# DESIGN COLLABORATIVE Pty Limited

28 May 2025  
Ref: 252145.2L

Submission on behalf of the Owners' Corporations of 'Metro Residences' – 'Metro View' (SP 88677) at 69 Albert St, 'Metro Spire' (SP 88678) at 1 Post Office Lane and 'Metro Grand' (SP 88679) at 438 Victoria Avenue, Chatswood – SSD-63324208 410-416 Victoria Avenue, Chatswood – Construction of a build to rent (BTR) development with ground and first floor retail premises, 260 BTR units, communal facilities and 3 levels of basement

DRAWING TITLE 18.03.25 VIEWS FROM THE SUN

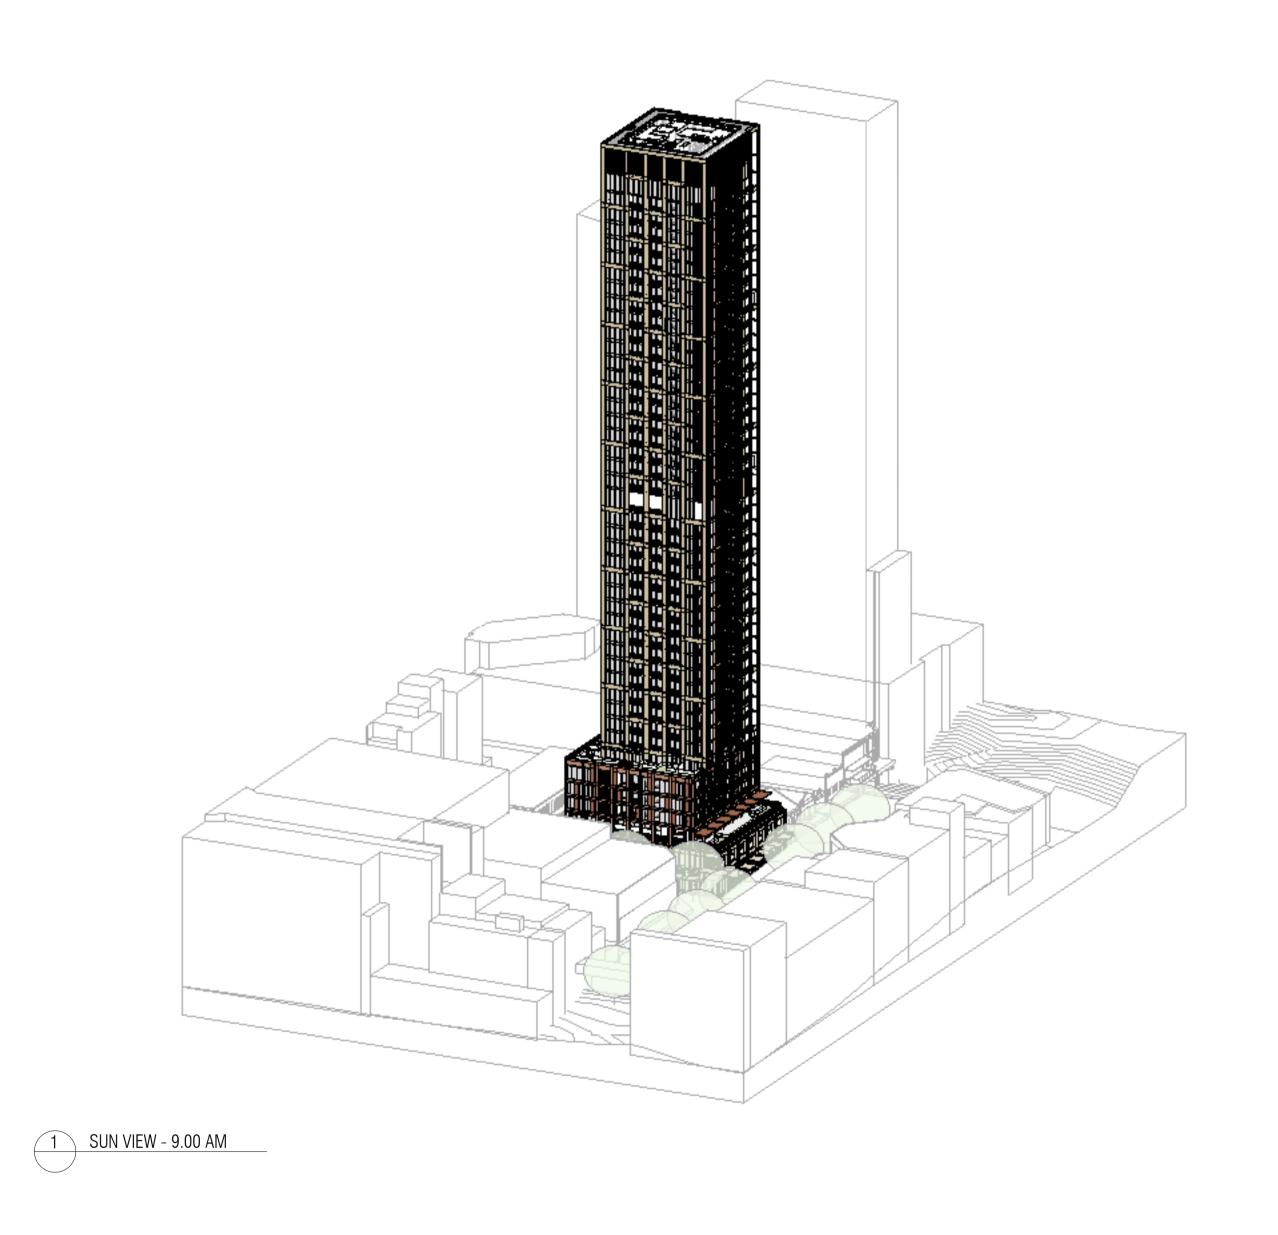
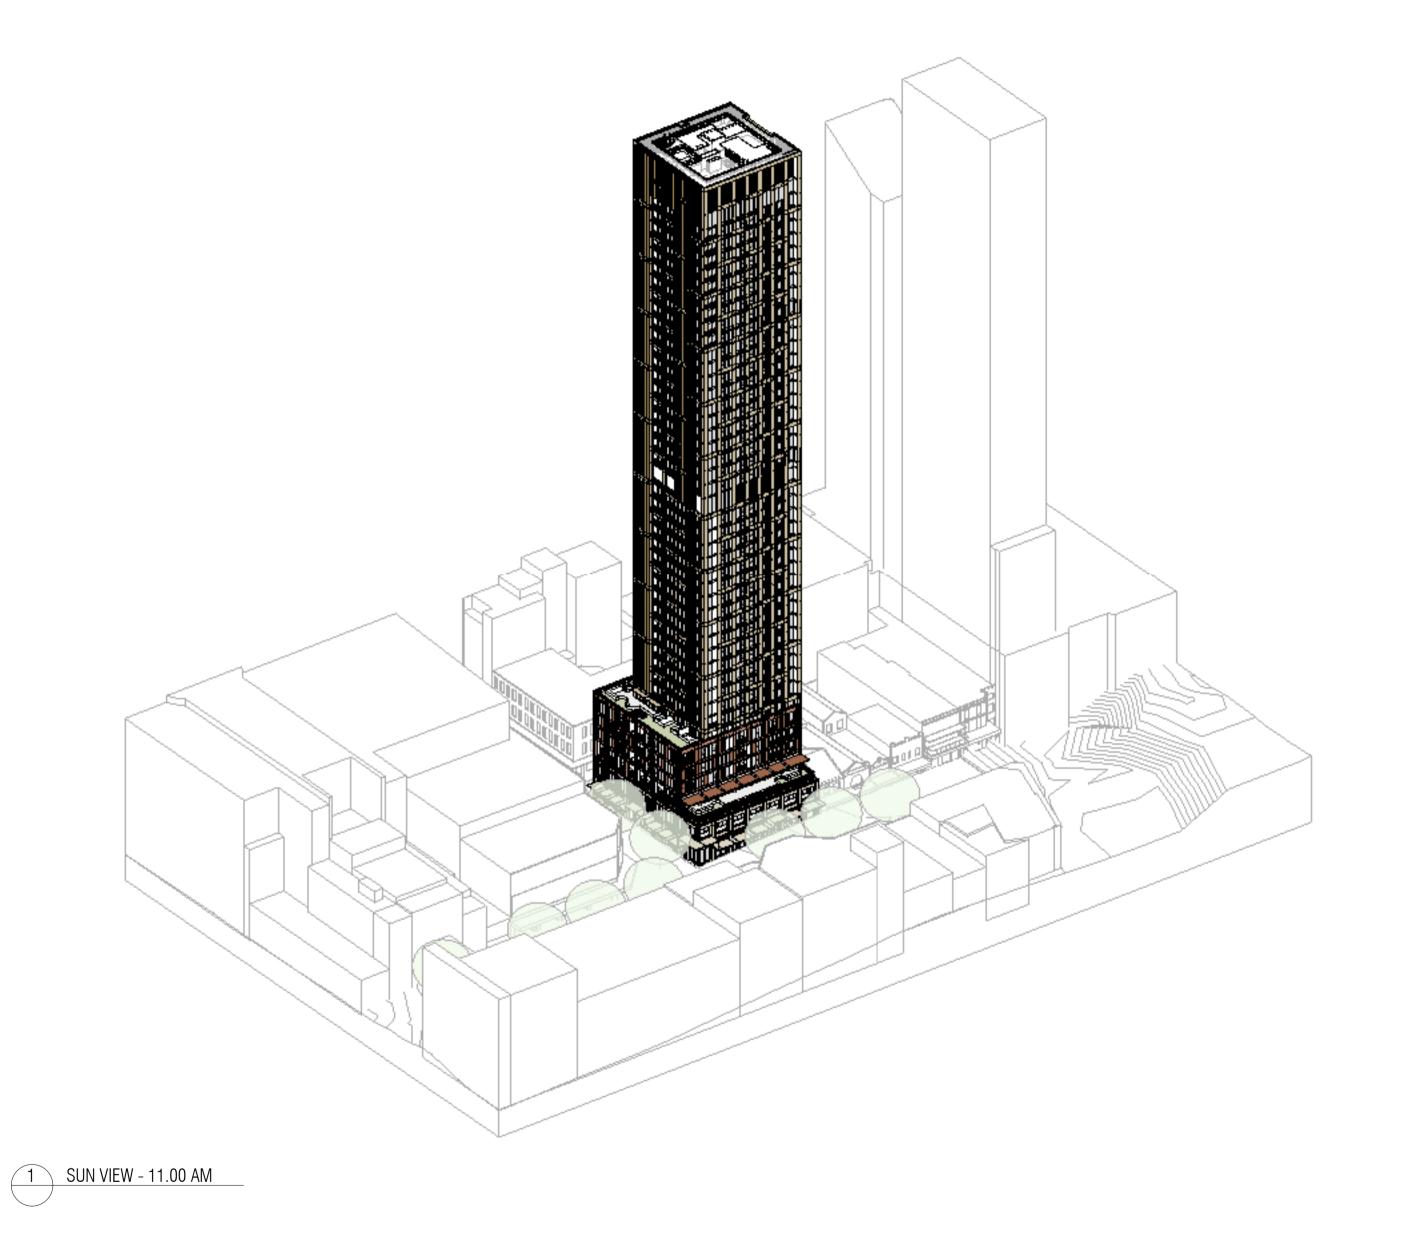
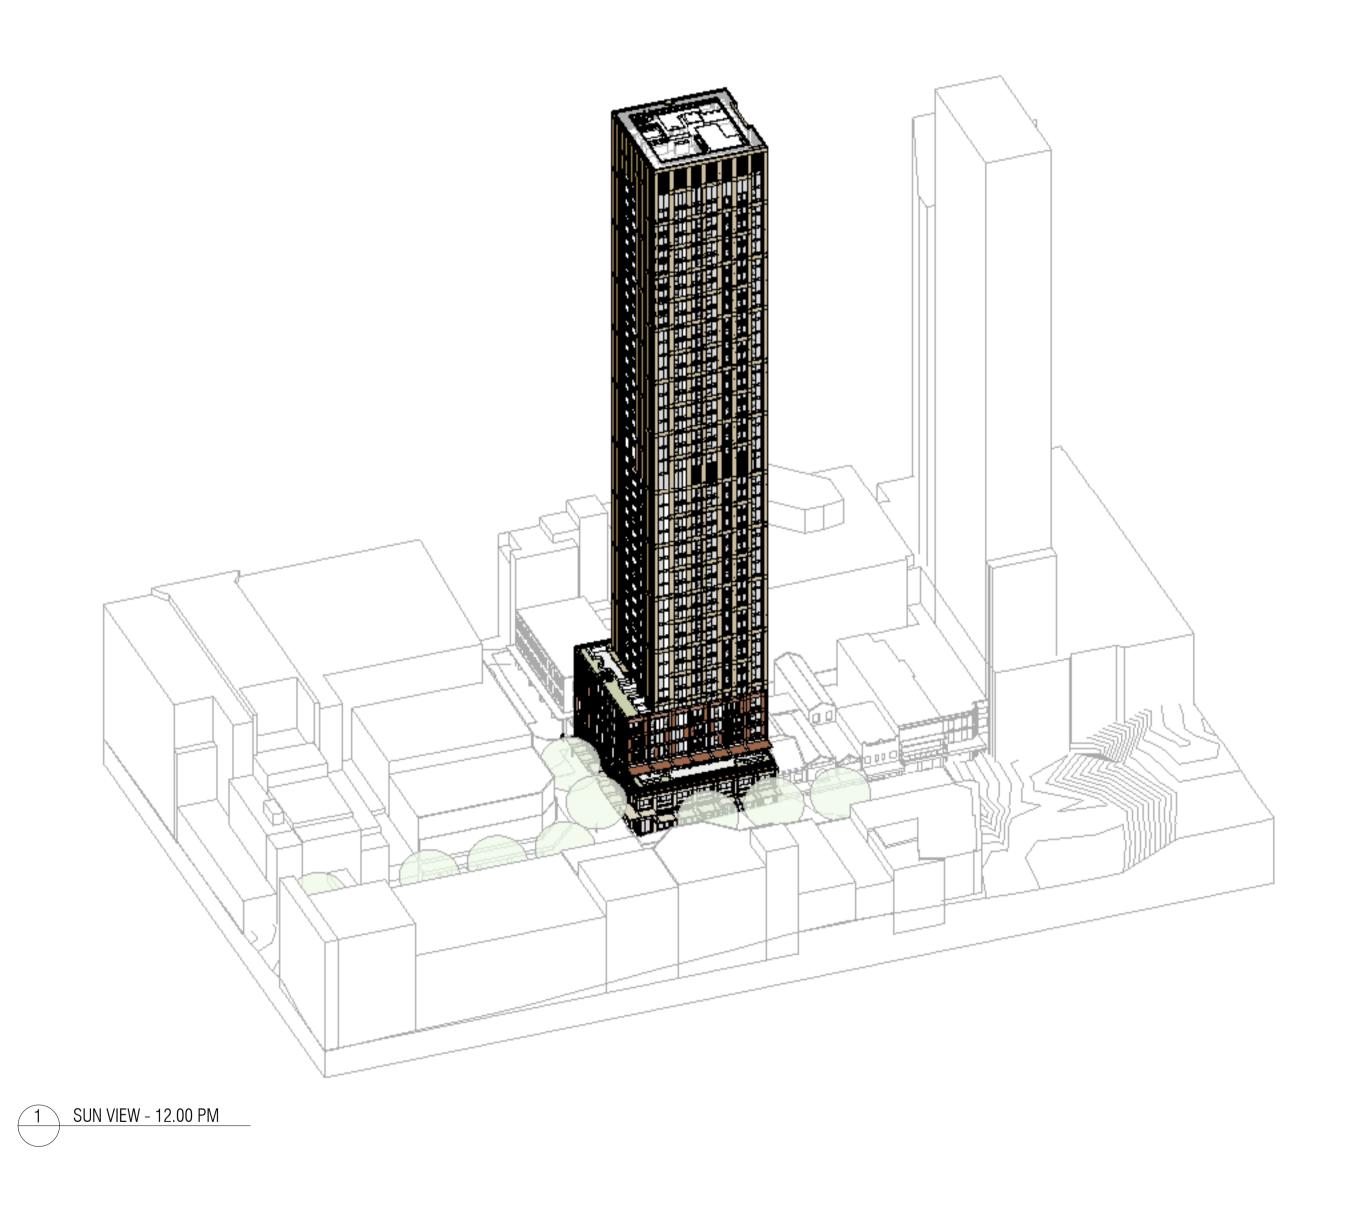
The proposal will result in additional overshadowing of Metro Spire and Metro View as shown in the midwinter shadow diagrams and 'Sun Eye View' diagrams from the EIS (p. 93)/architectural plans (see **Figures 2** and **3**).

As shown above, at 9am and 10am, the proposal will overshadow most of the eastern façade of Metro View. At 9am, solar access is retained only to the SE corner of the building. At 10am, solar access is retained to the northern elevation/NE corner. This level of impact represents a significant and marked reduction in solar access to these units compared with the existing situation.

However, at 12 noon, due to the angle of the façade, the diagrams show that solar access would not be achieved to the south-east-facing units in Metro View.
